REQUEST

Current Zoning: CG (general commercial) and MHP (manufactured home park)
Proposed Zoning: N2-A(CD) (neighborhood 2-A, conditional)

Approximately 16.91 acres located on the west side of Old Statesville Road and north and south side of Ratcliff Lane, south of West W.T. Harris Boulevard.

The petition proposes the development of up to 198 triplex, quadraplex, and multi-family attached dwelling units. The site is currently developed with a manufactured home park and two single-family detached dwellings.

TECHNICAL DATA  
 SHEET NUMBER  
**RZ-1**

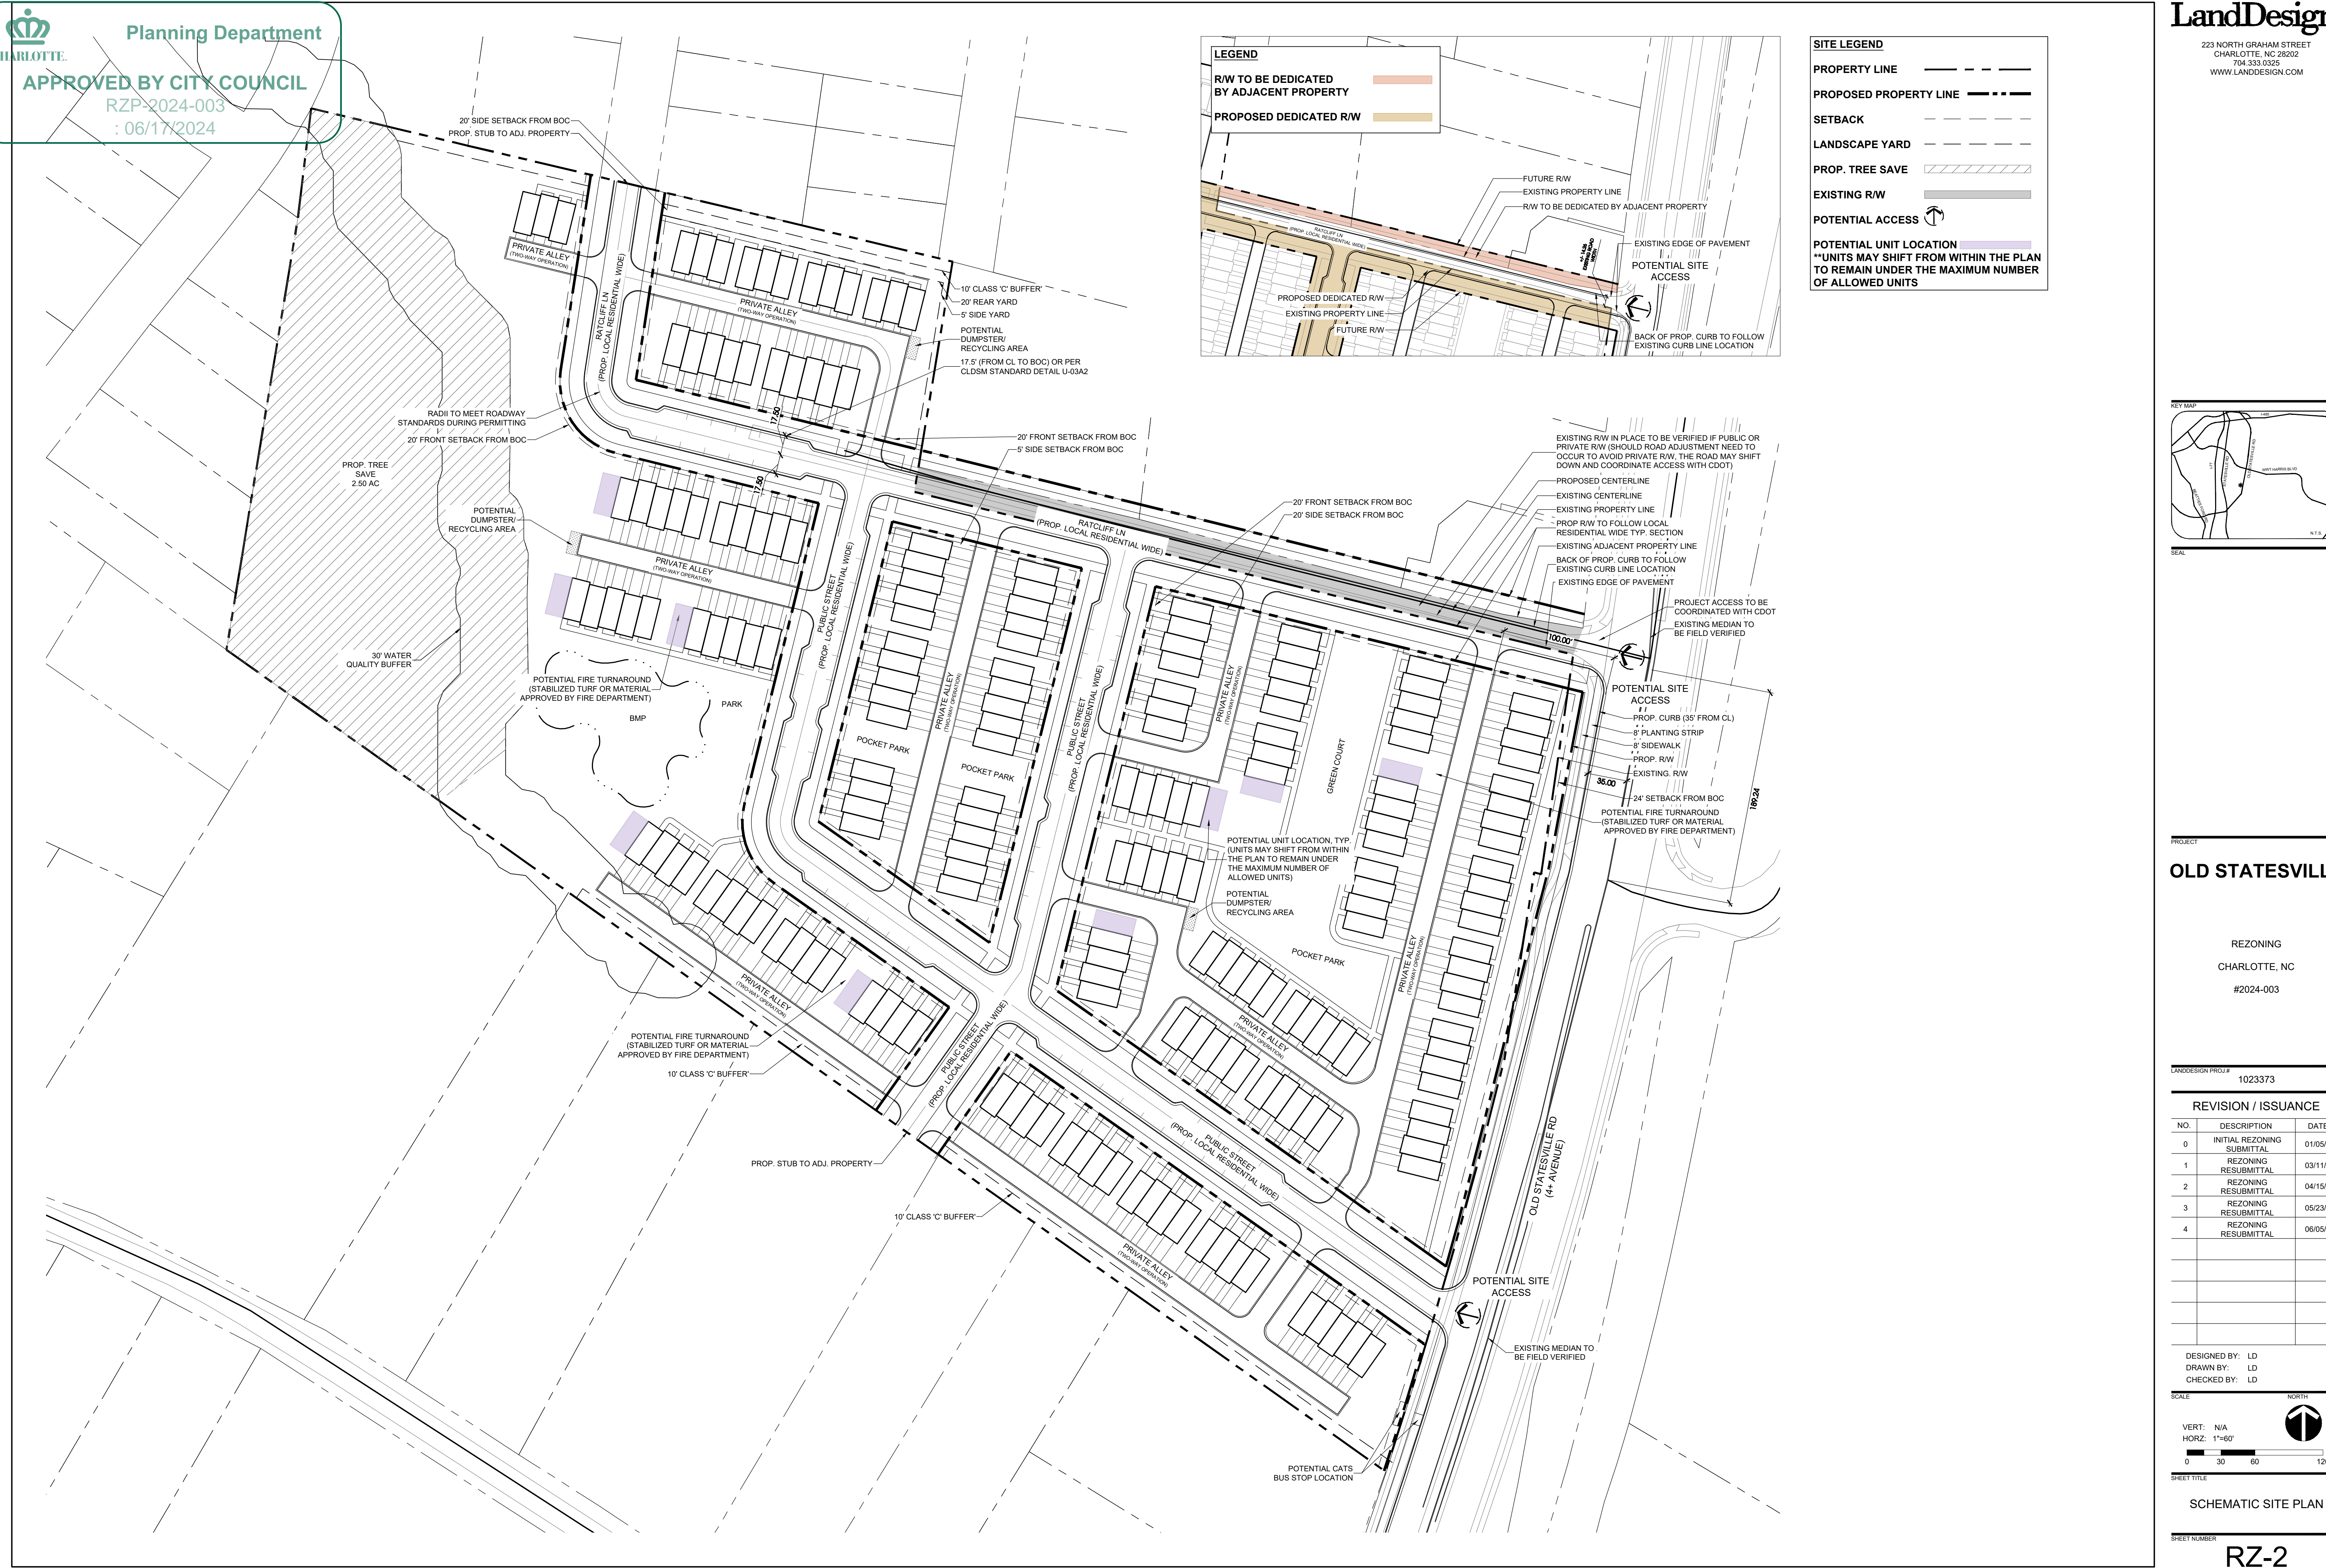
3. Plan sheet RZ-1 specifies a maximum dwelling count of 200 units while the rest of the plan specifies 198.
